MR. J. C. MILLS
8, HIGHDOWN CLOSE
FERRING
WORTHING
SUSSEX

REF. No FC/69/22/HH.

25 MAY 2022

PROPOSED SOUTH ELEVATION 1:50

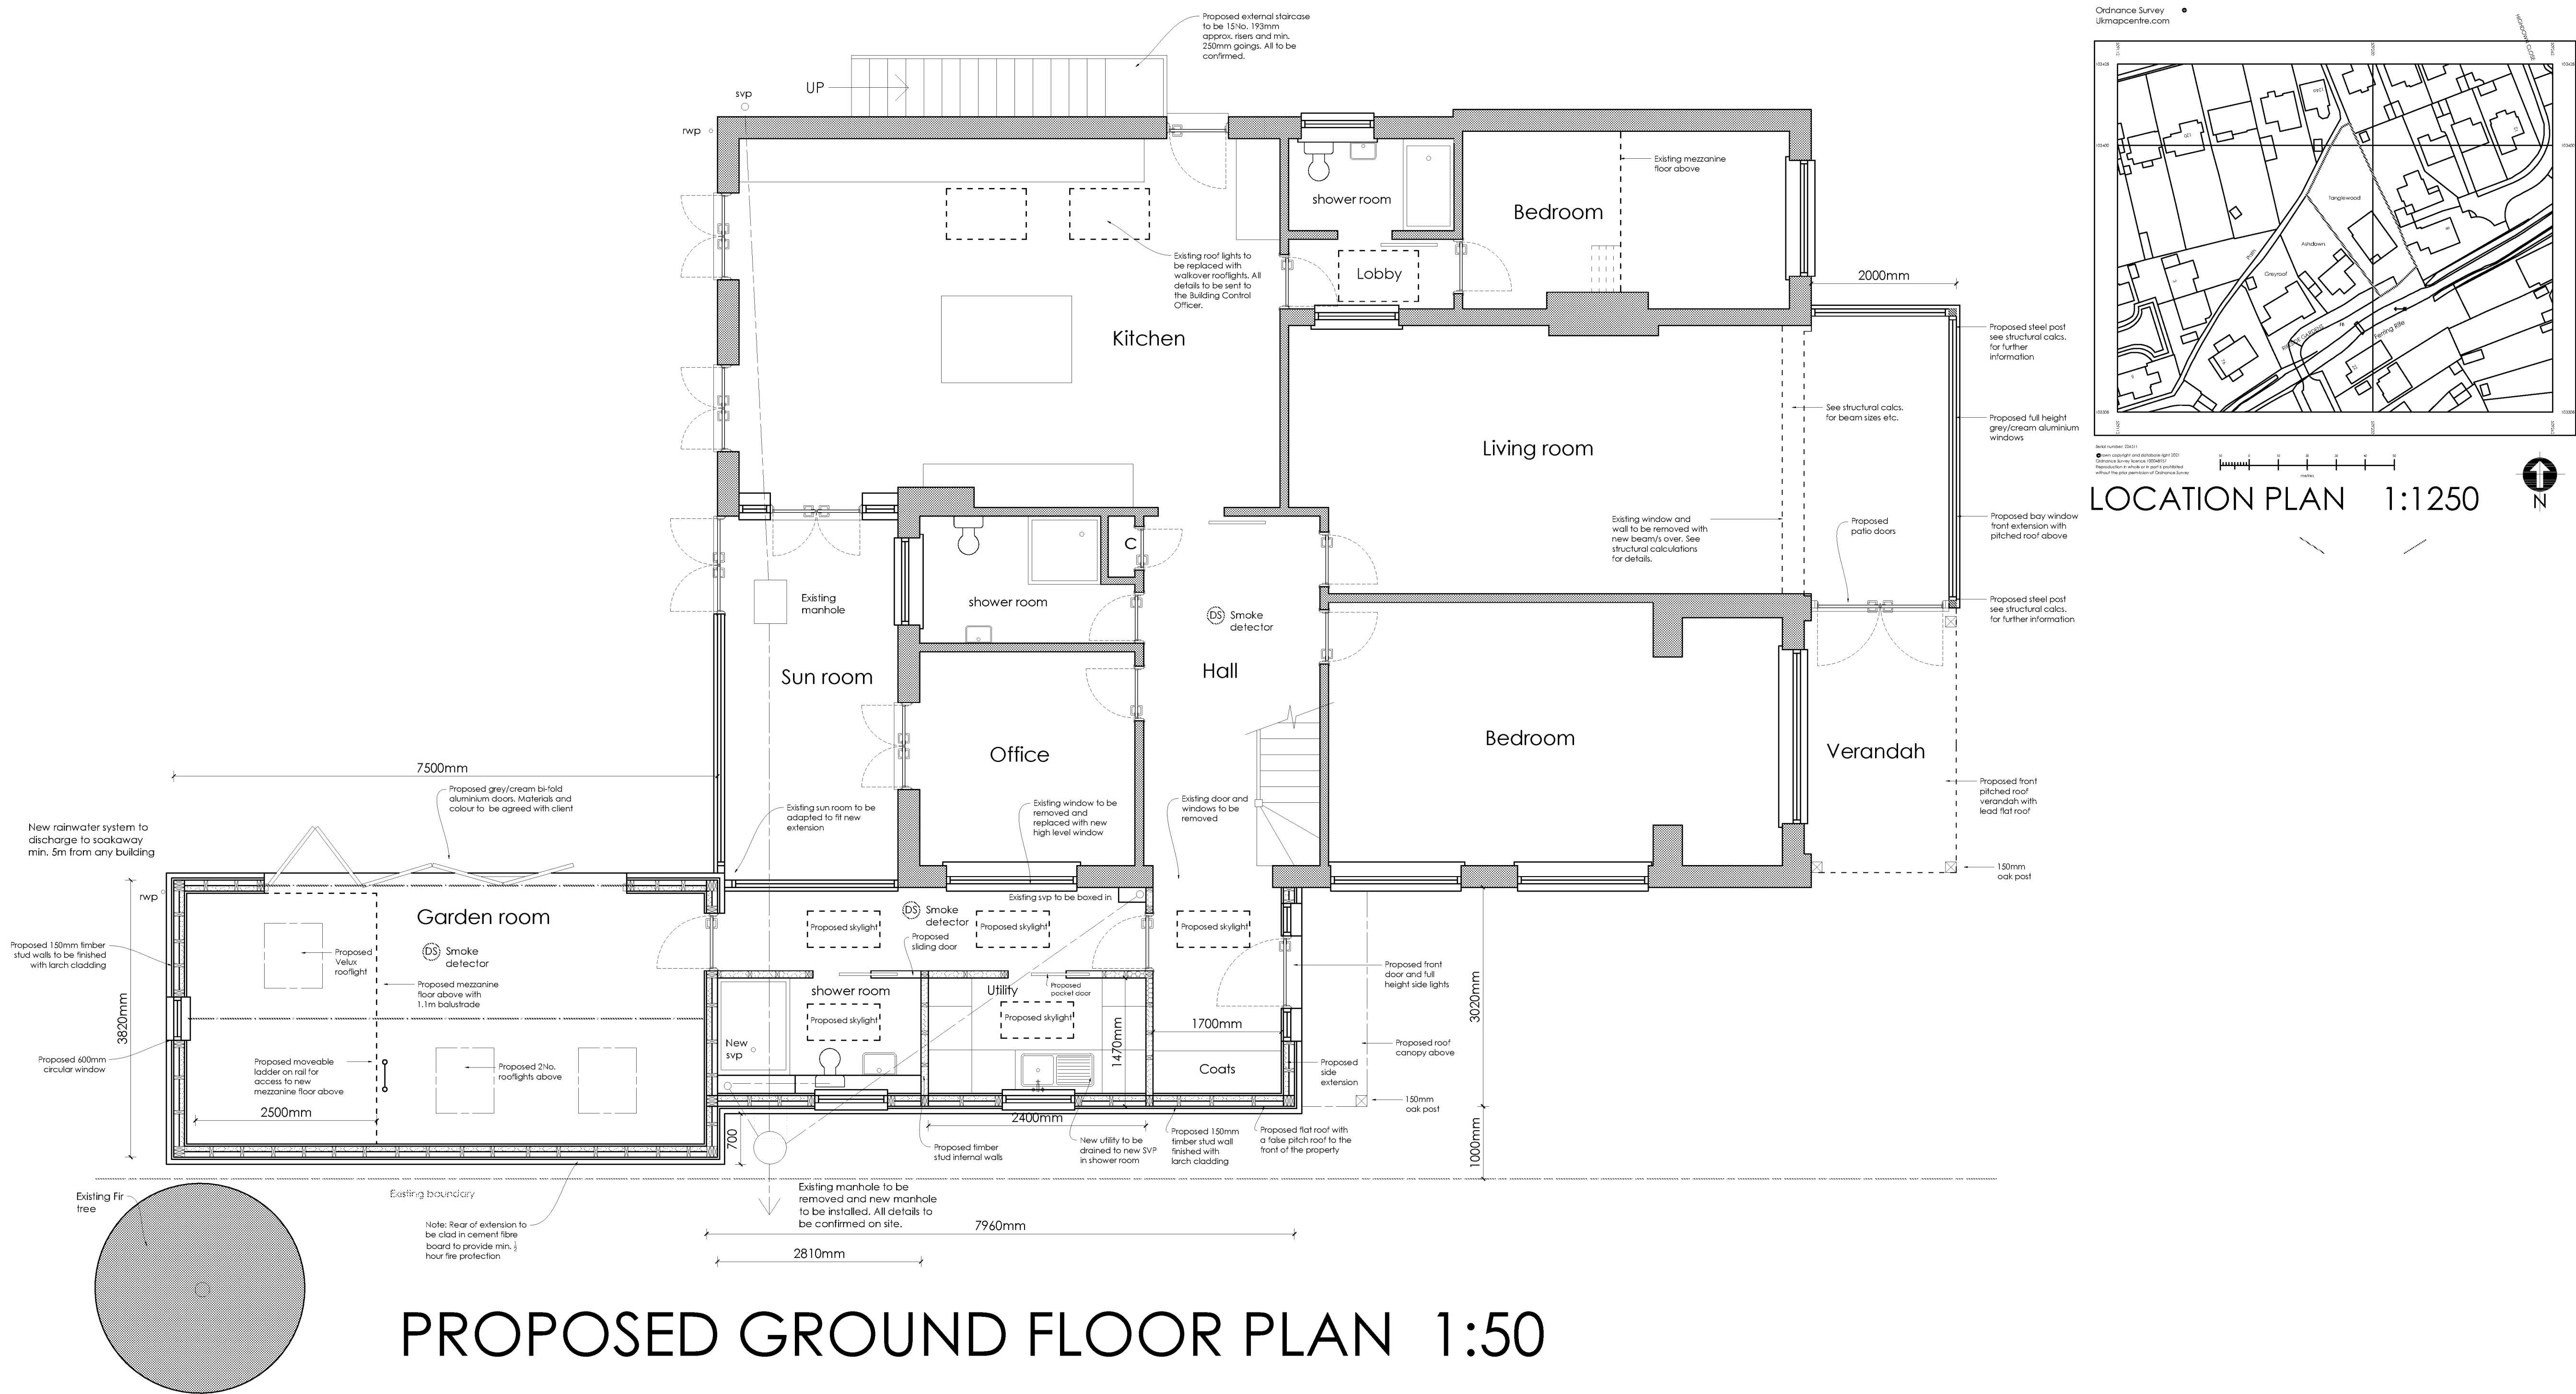
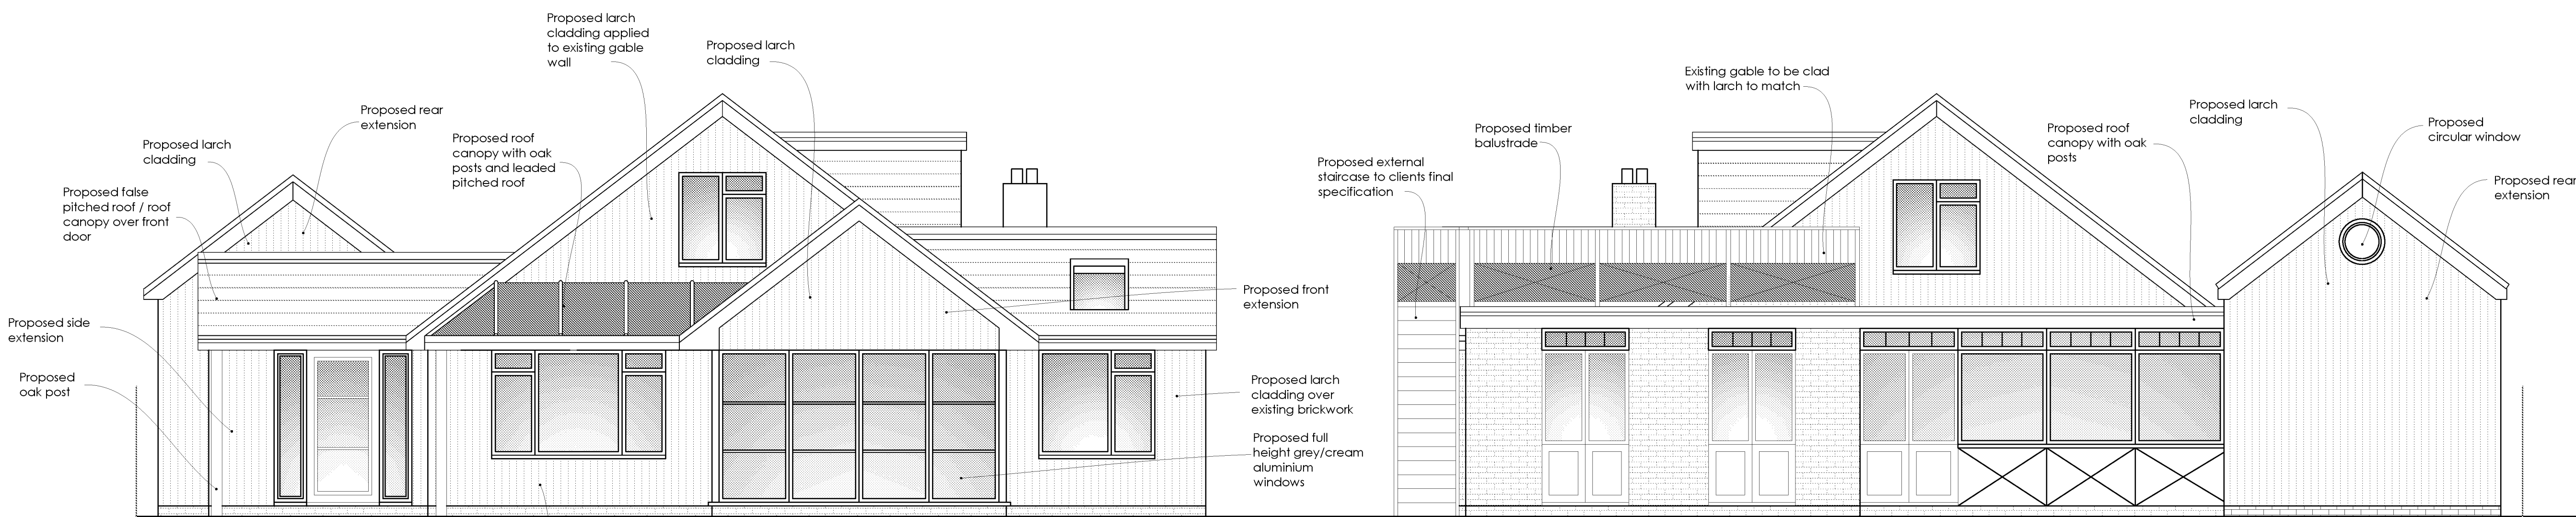
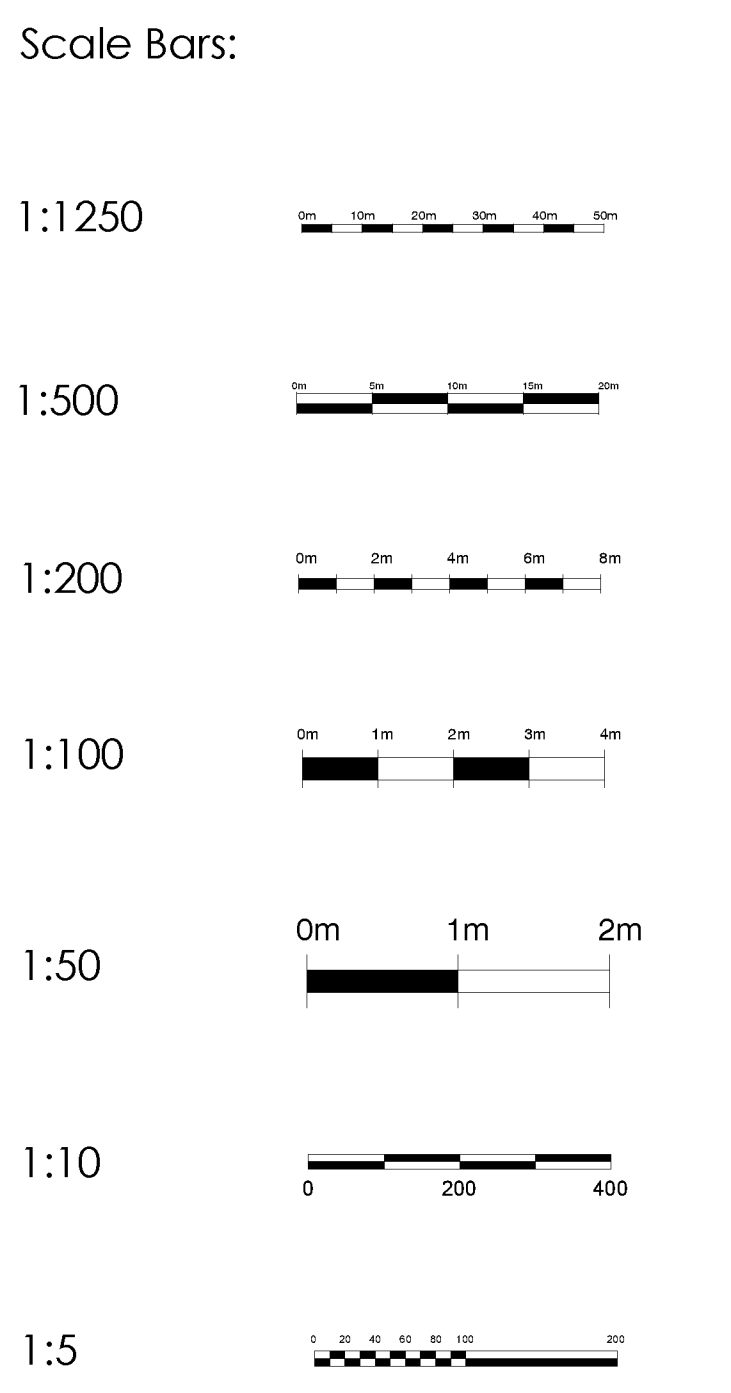
My neighbours intension is to build a single story extension the the front of their bungalow facing South. which I understood would go beyond the Building line of the property.

PROPOSED EAST ELEVATION 1:50

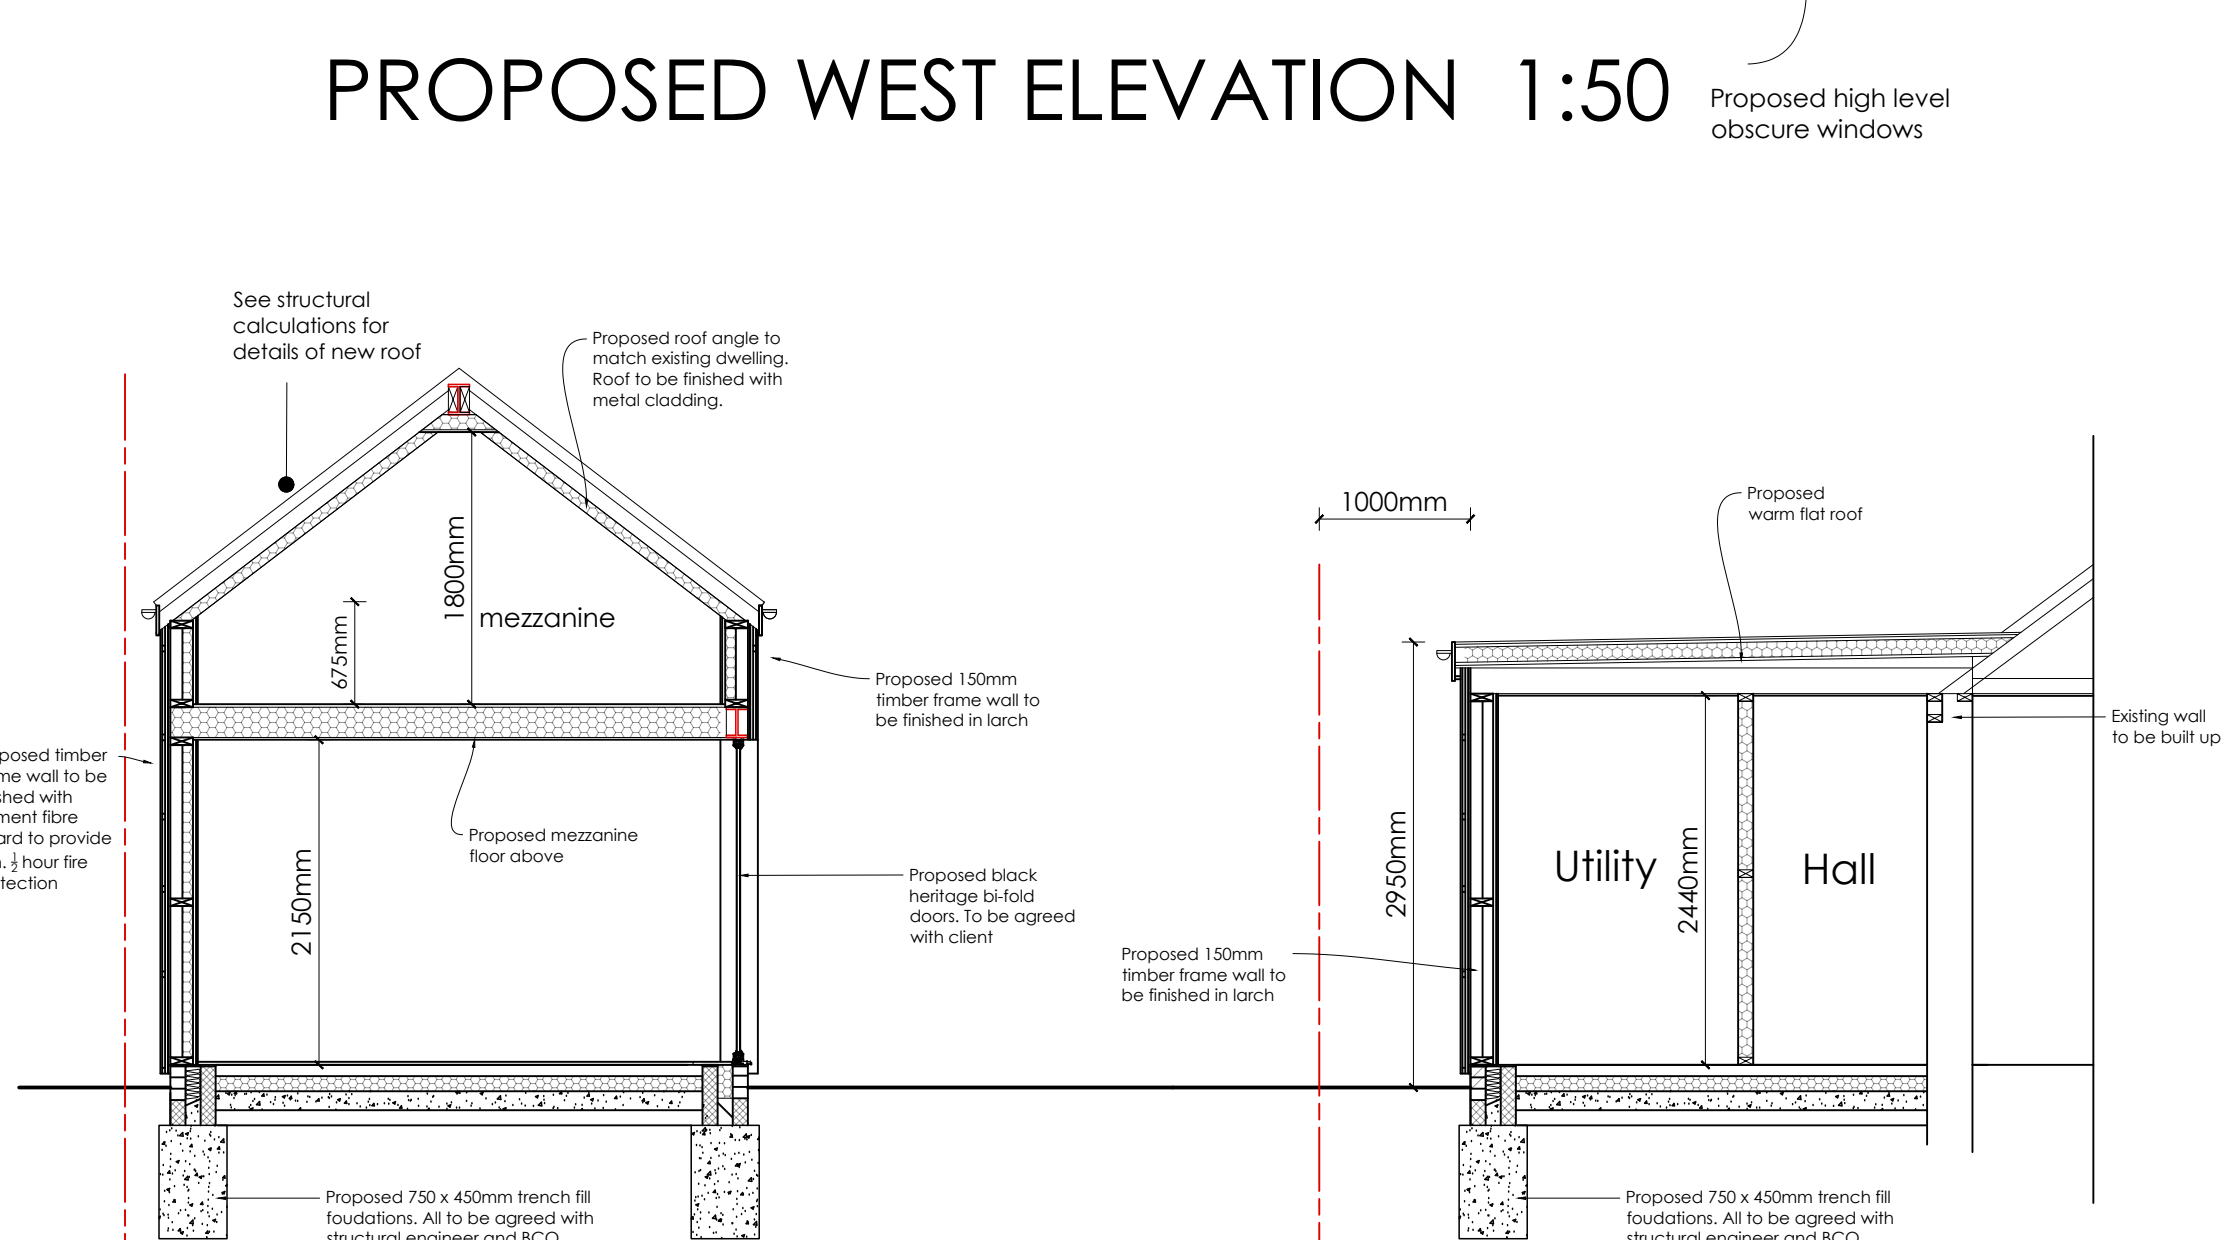
Also they intend to put up a exterior staircase on the East side, to gain access to the existing flat roof, to use as a terrace

This would encroach on my privacy as they will have full view of my rear garden.
